Huntlee Mod10 Response to Submissions

I write to you on behalf of Huntlee Pty Ltd in regard to the proposed S4.55 1A Modification Application (MOD 10) to Project Approval MP10_0137. The purpose of this letter is to provide a response to the Submissions prepared by Government Agencies, organisations and individuals. A summary of the comments raised in each submission and responses are provided in **Table 1** below.

FIGURE 5D

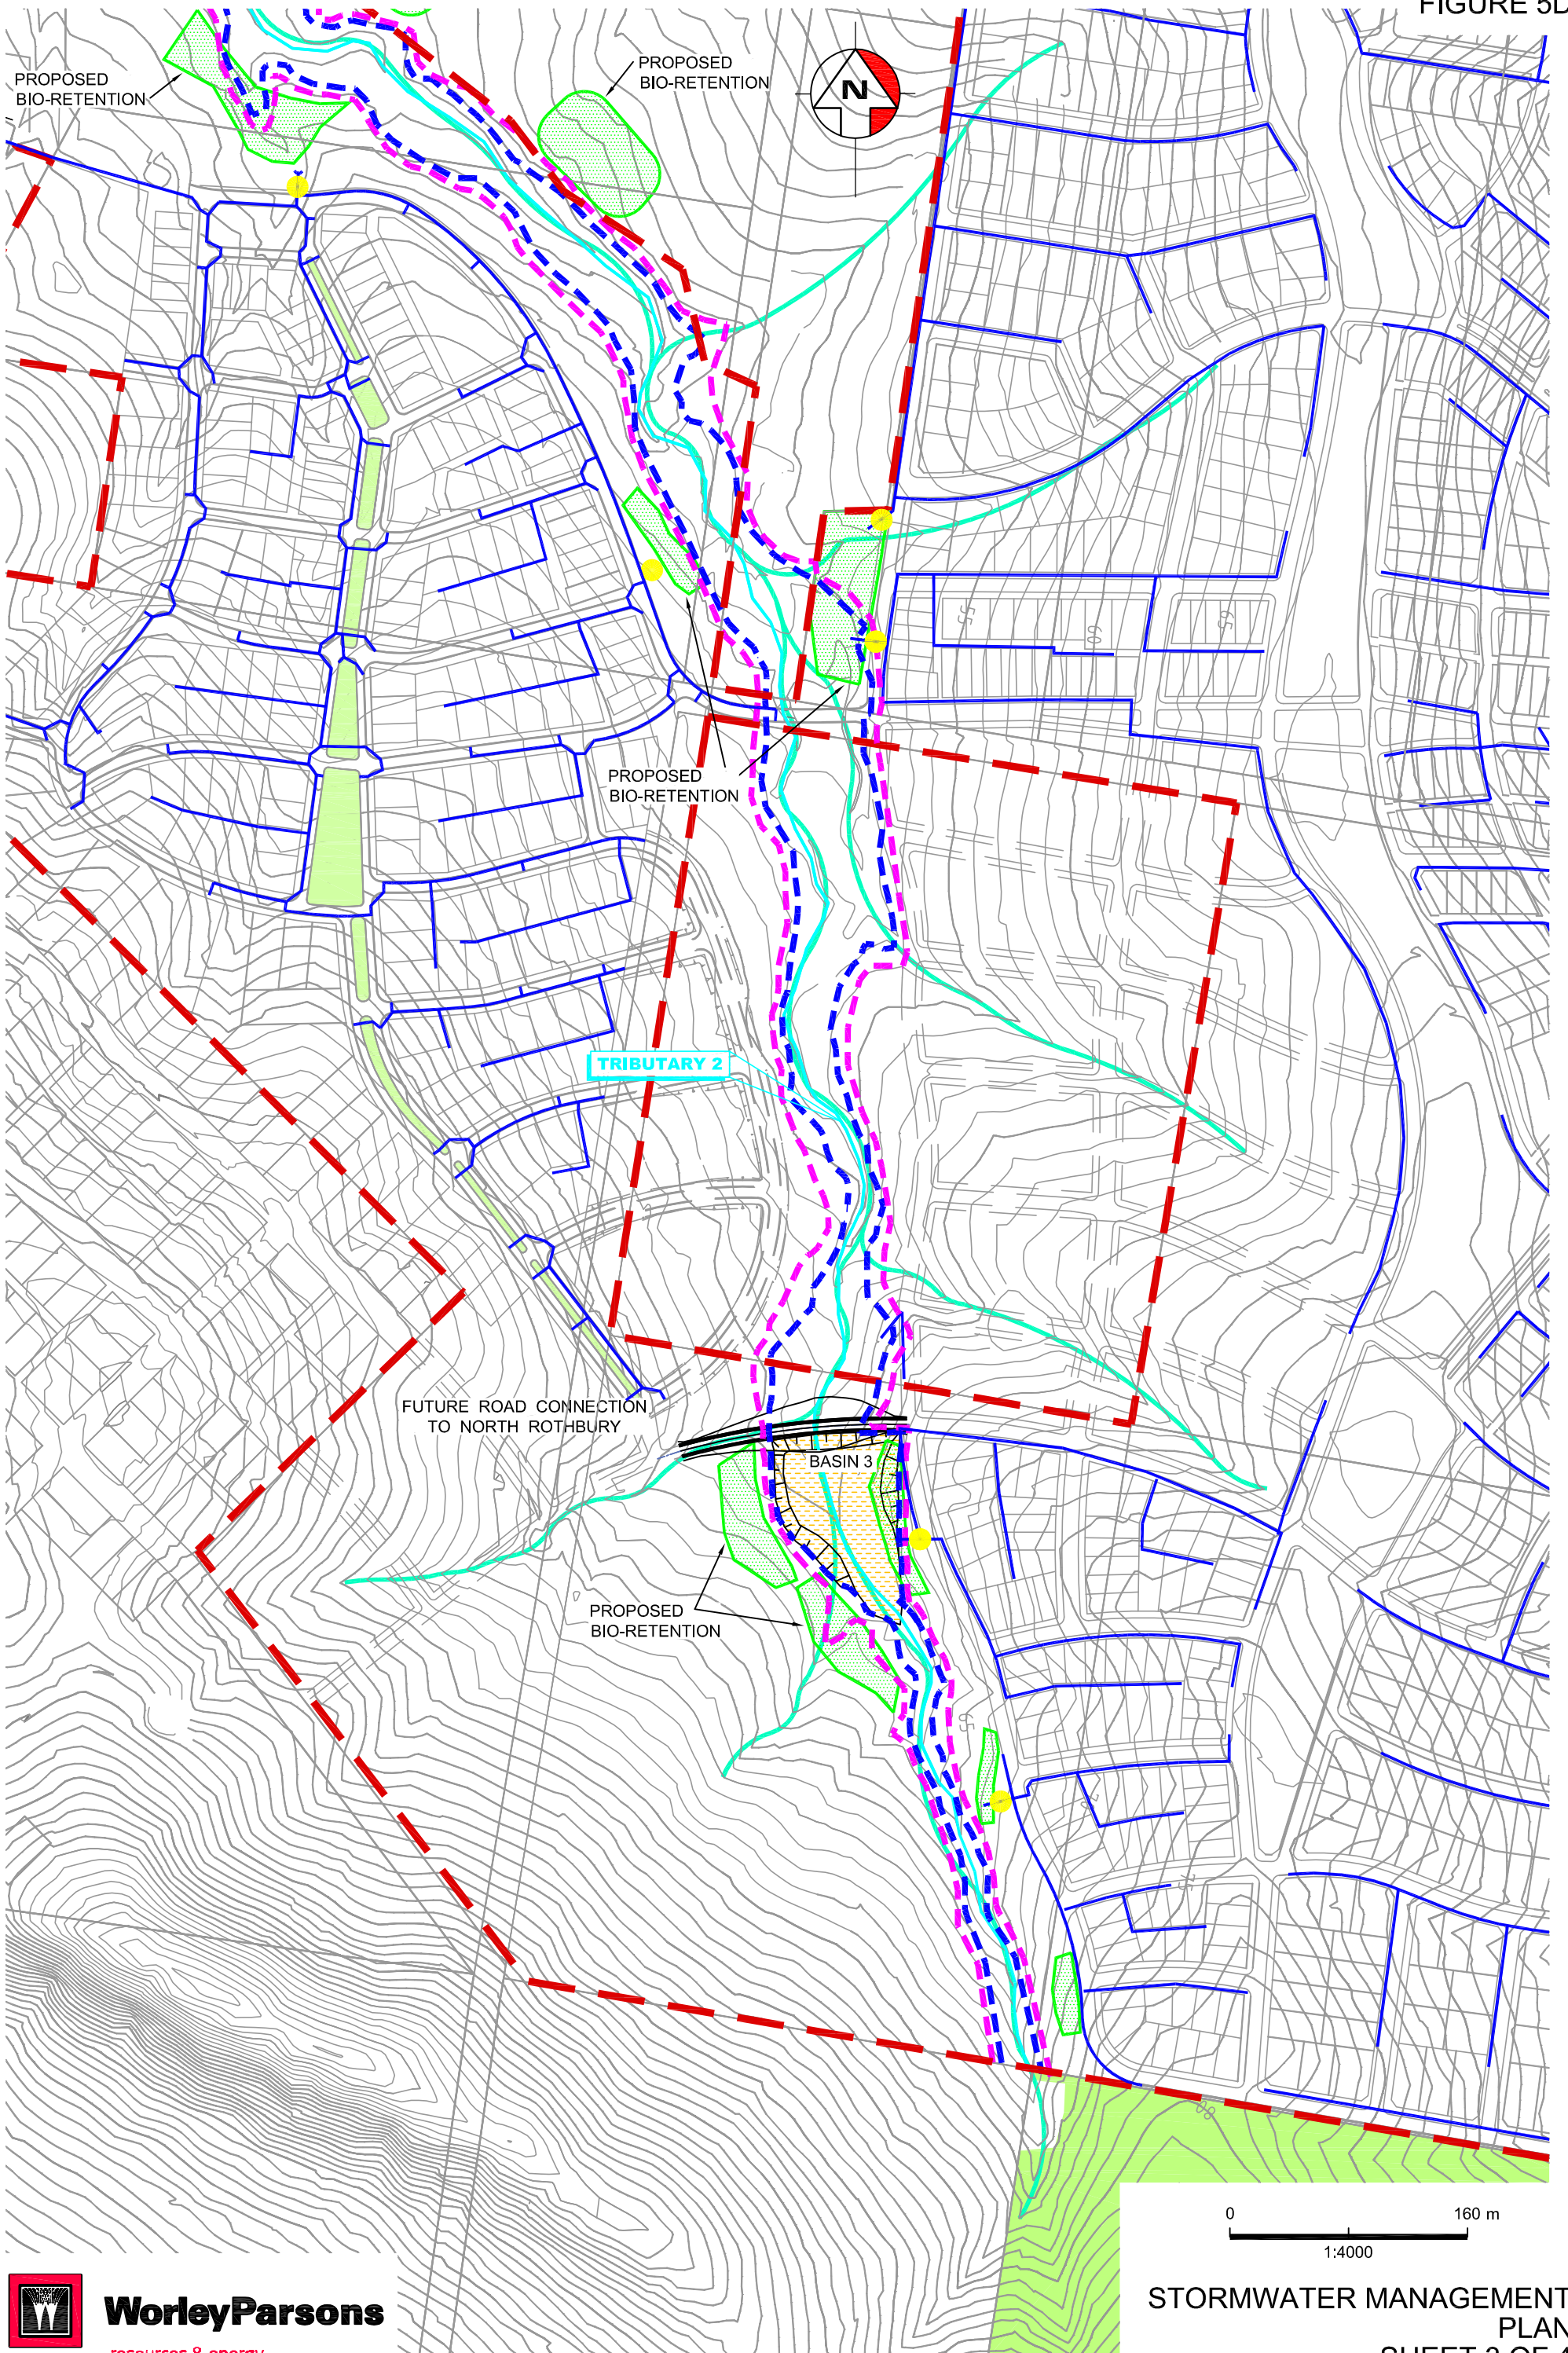
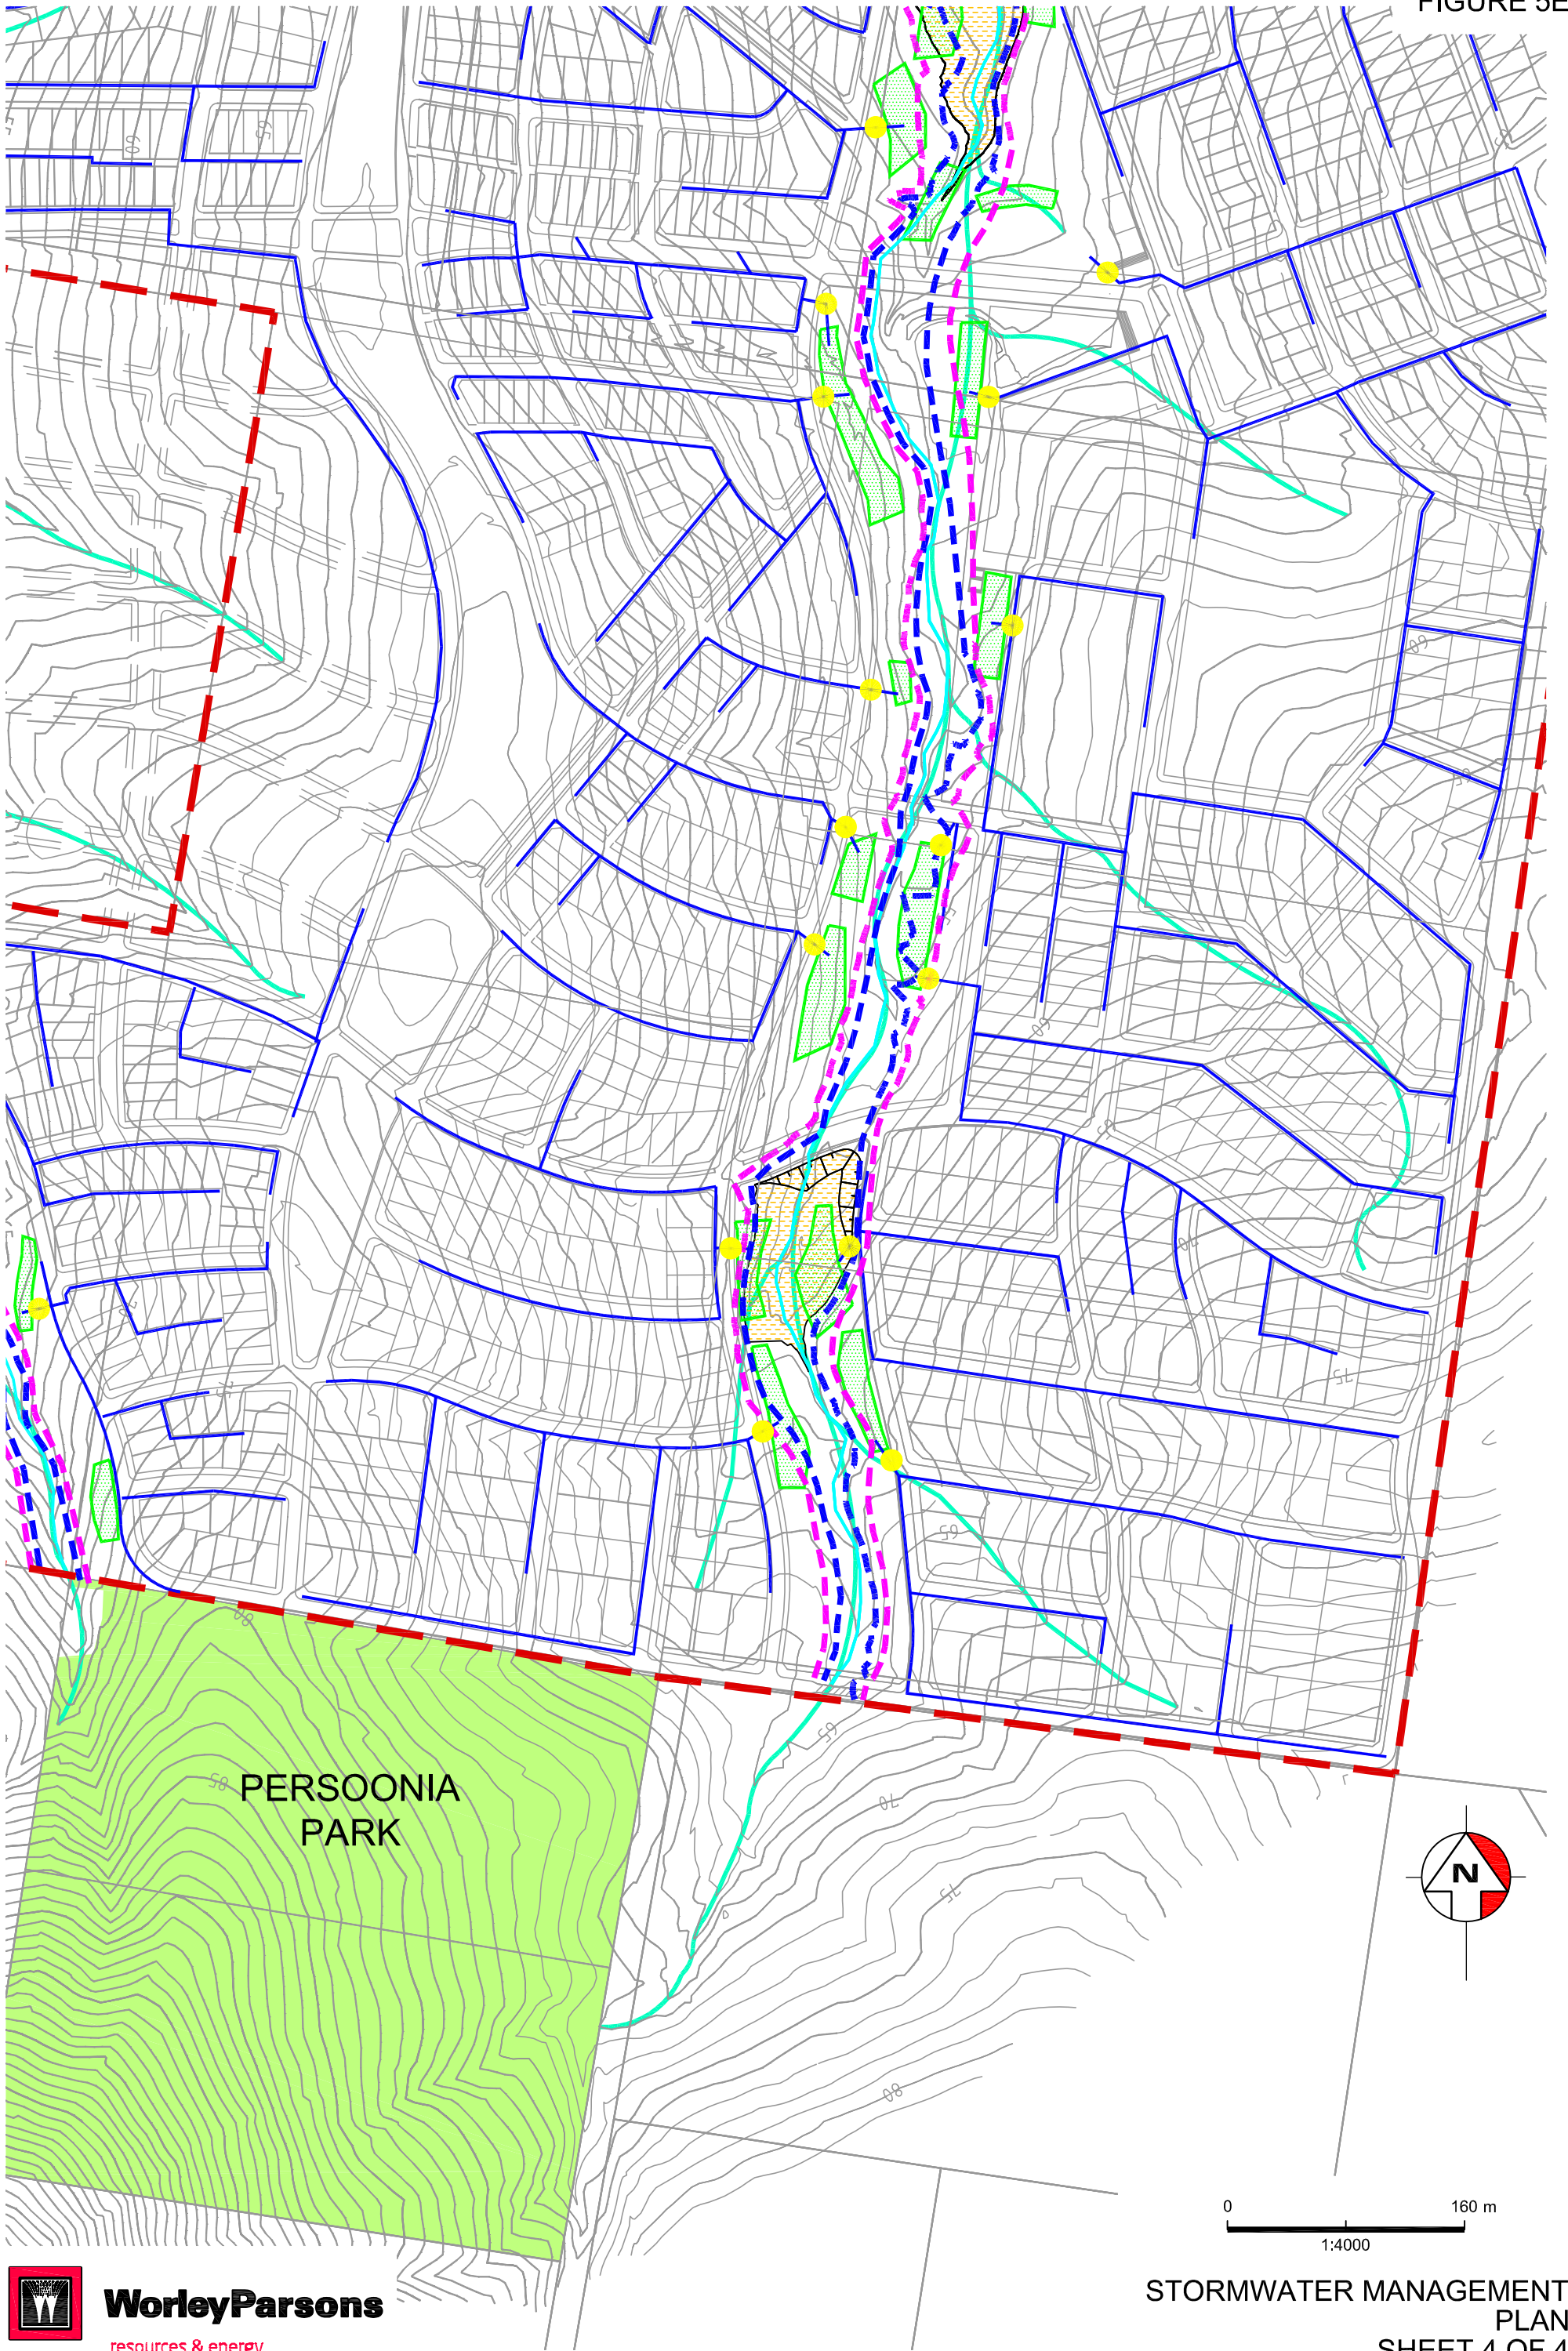
Cessnock Council	
The proposed stormwater detention basin in Substage 1 and Town Centre should not be identified as public open space. It presents a risk to the public and is not usable. Further it will have implications on the approval pathway due to Huntlee's Planning Agreement with Council.	Currently the VPA does not contain any other definition which can be used to identify general detention/water quality structures rather than General Public Open Space. The approved stormwater management plans include many stormwater management structures within riparian corridors and public open space within the development. Regardless of the definition, the areas will be handed over to Council and so inclusion within the VPA ensures Council has an ability to track the area and dedication of these assets. Should Council wish to amend the VPA to identify these separately or have them removed from the VPA, Huntlee P/L is prepared to negotiate an amendment to the VPA prior to the dedication of the stormwater management structures that are the subject of this modification.
